Planning & Urban Development Department

RAIA SABATO S
101 DENNETT ST
PORTLAND, ME 04102**CBL: 427 D019001**
Located at: 29 ARCADIA ST**Certified Mail 7010 1870 0002 8136 8961**

Inspection Violations

29 ARCADIA ST.

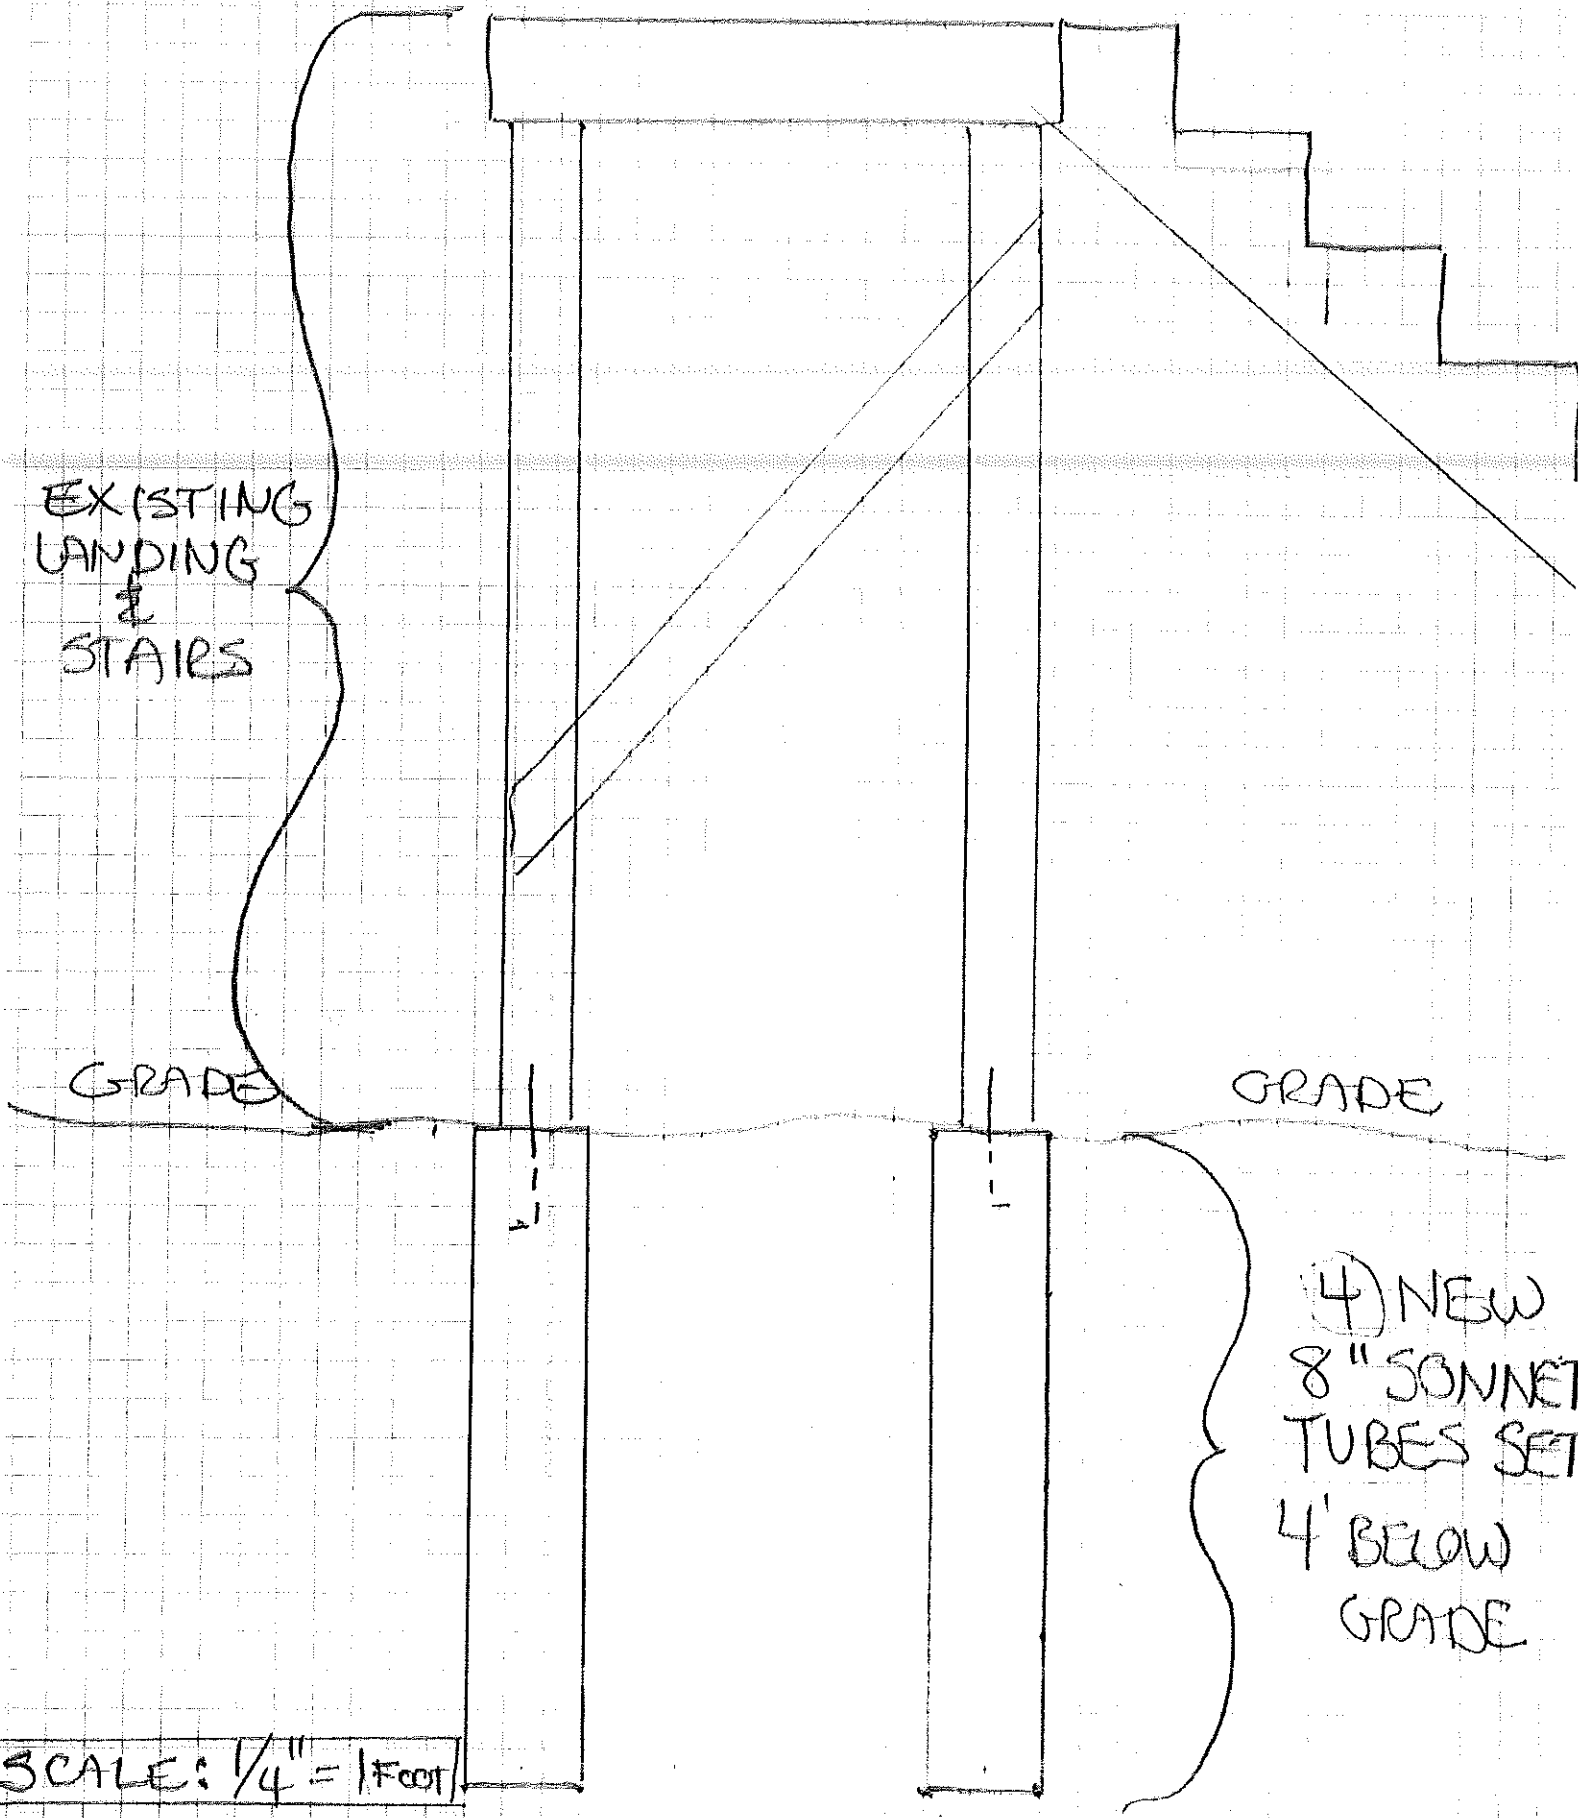
1) 6-108.(d) Exterior Rear Deck

The rear stairs are structurally compromised and unsafe.

Every inside and outside stairway, stairwell, stairs, and porch and any appurtenances thereto shall be structurally sound, in good repair, and safe to use.
